# Rezoning Transportation Analysis

Petition Number: 2023-001

General Location Identifier: 07112129, 07112130, and 07112131.

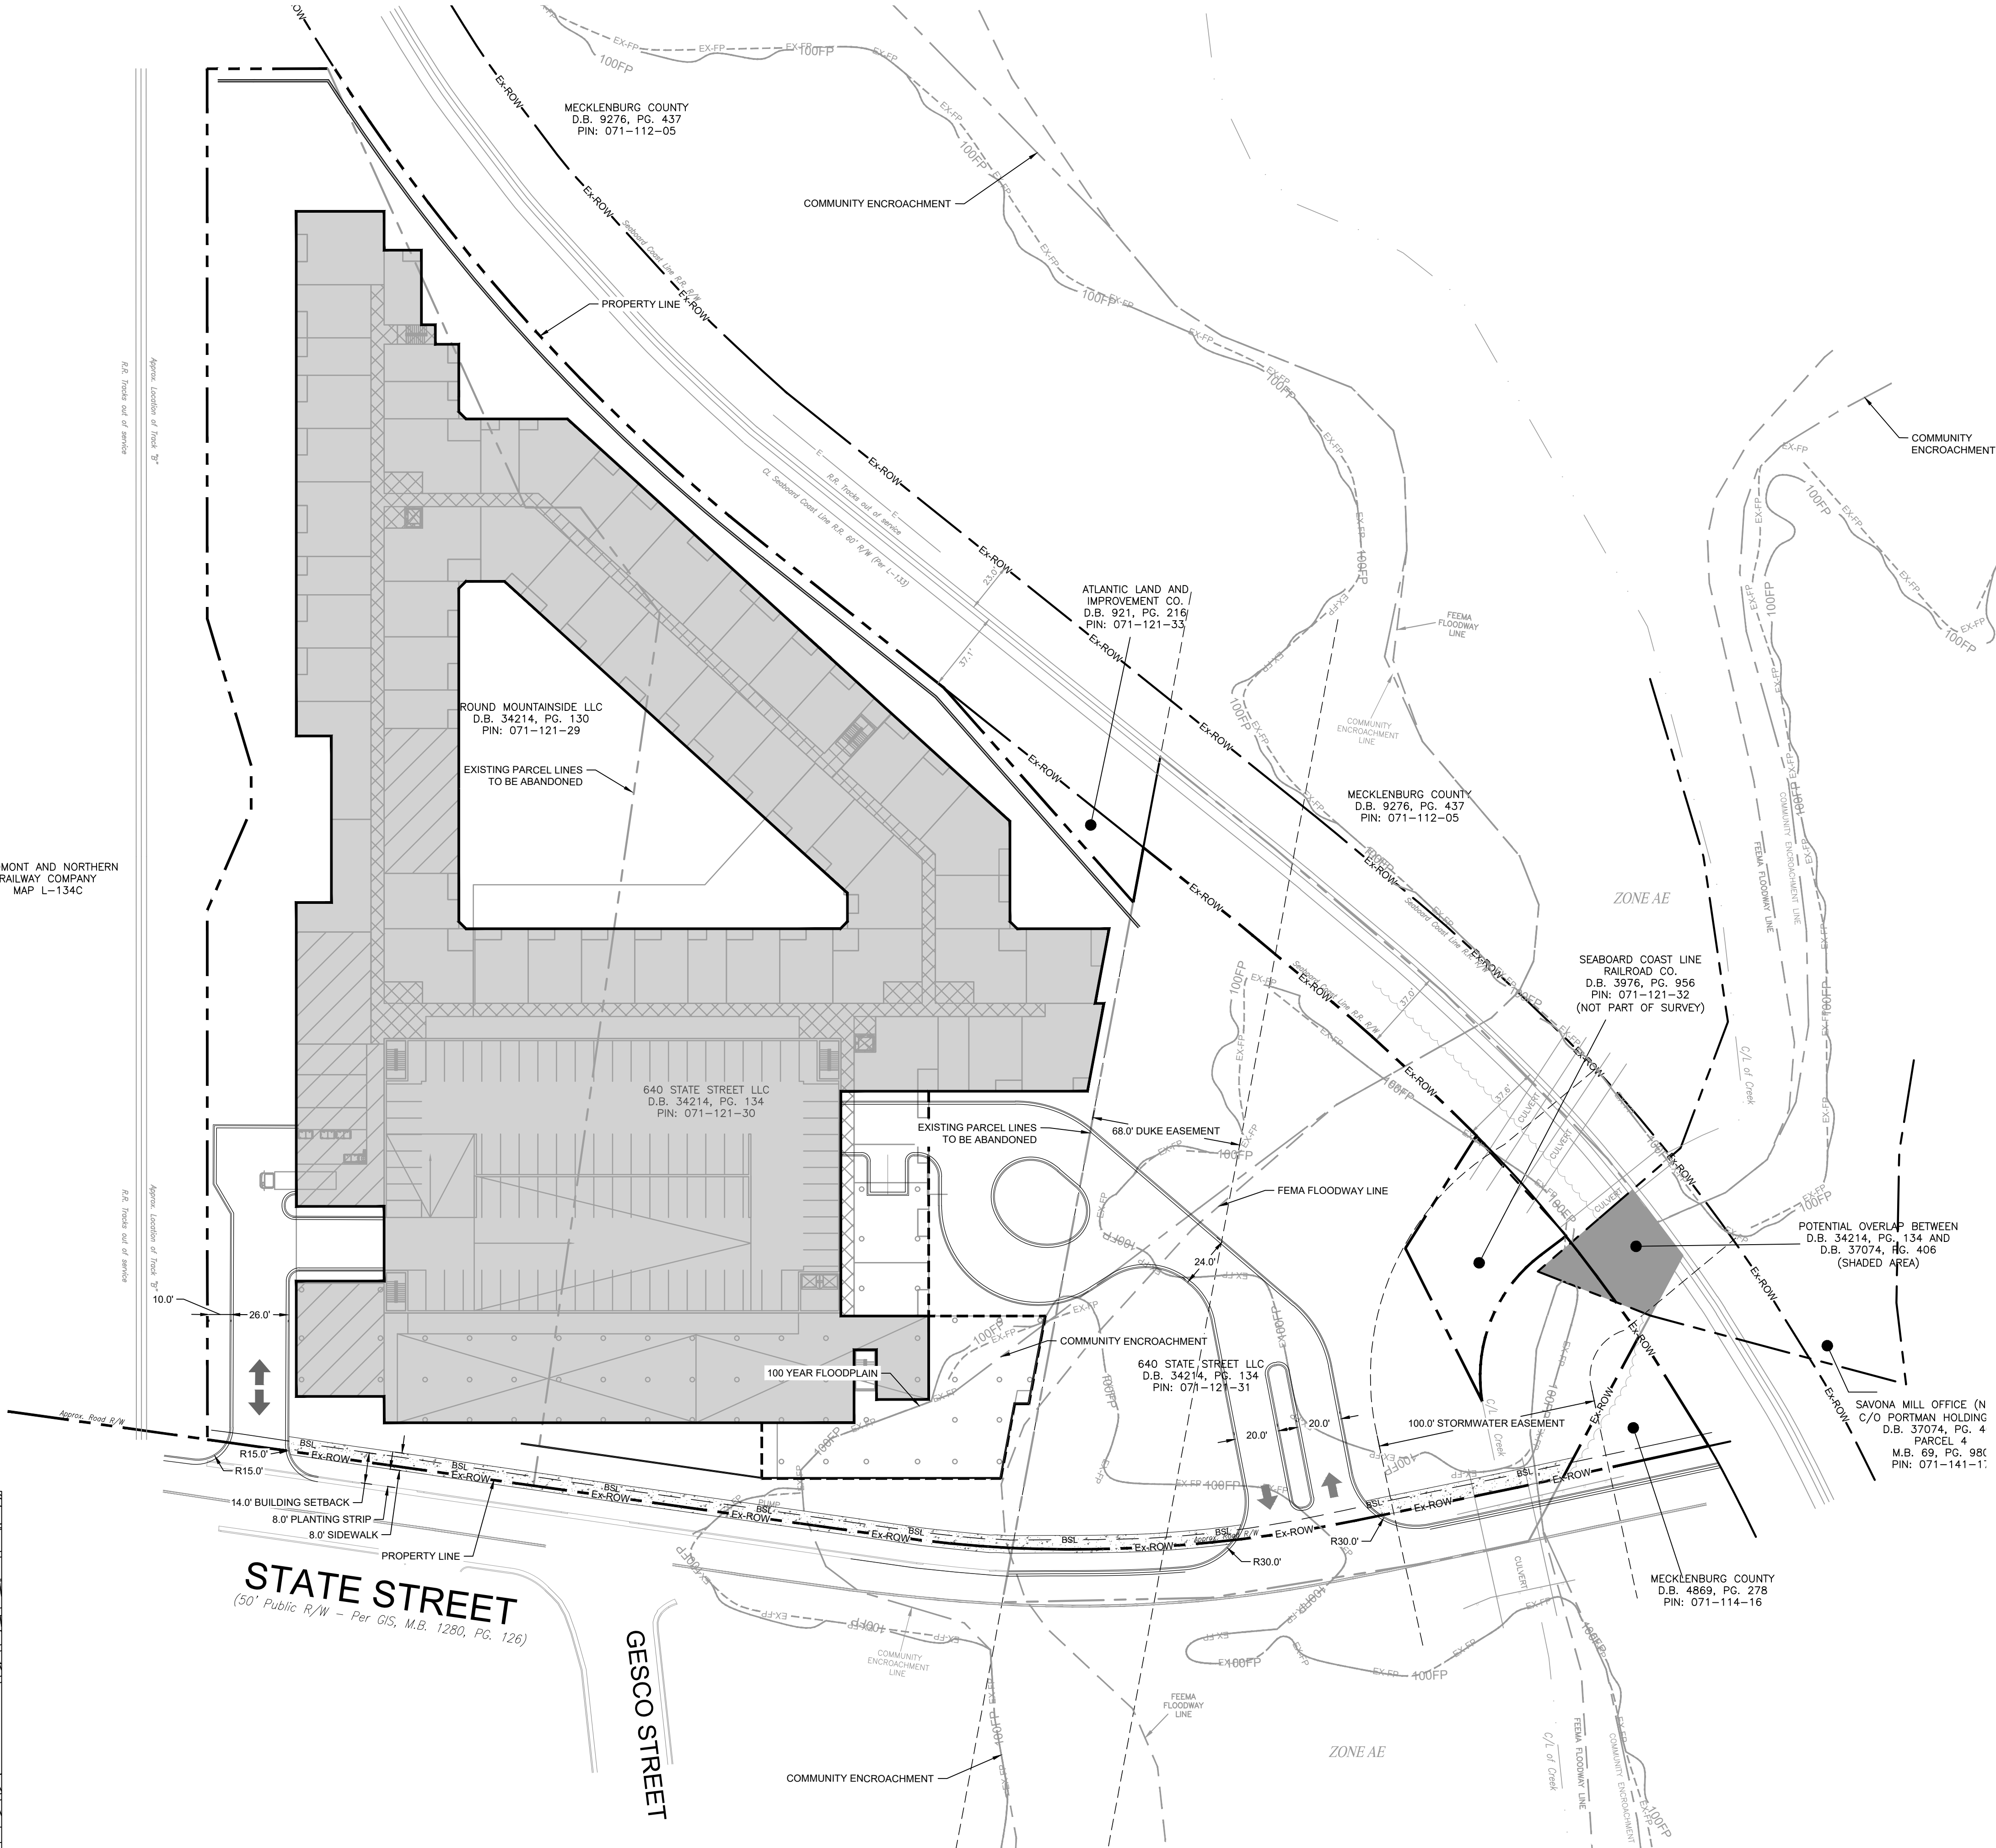
### 1. ~~Curbline:~~

a. ~~**State Street:** The future location of curb and gutter is in its existing location.~~

~~NOTE: Additional distance from center line to back of curb may be required in locations where a median is present or around intersections and interchanges.~~

~~Label and dimension the curb and gutter from the centerline for each road on the site plan.~~

### 4. ~~Revise site plan and conditional note(s) to commit to dedicate 35.5 feet of right-of-way from the road centerline. The site plan shall label and dimension the right-of-way from the road centerline.~~
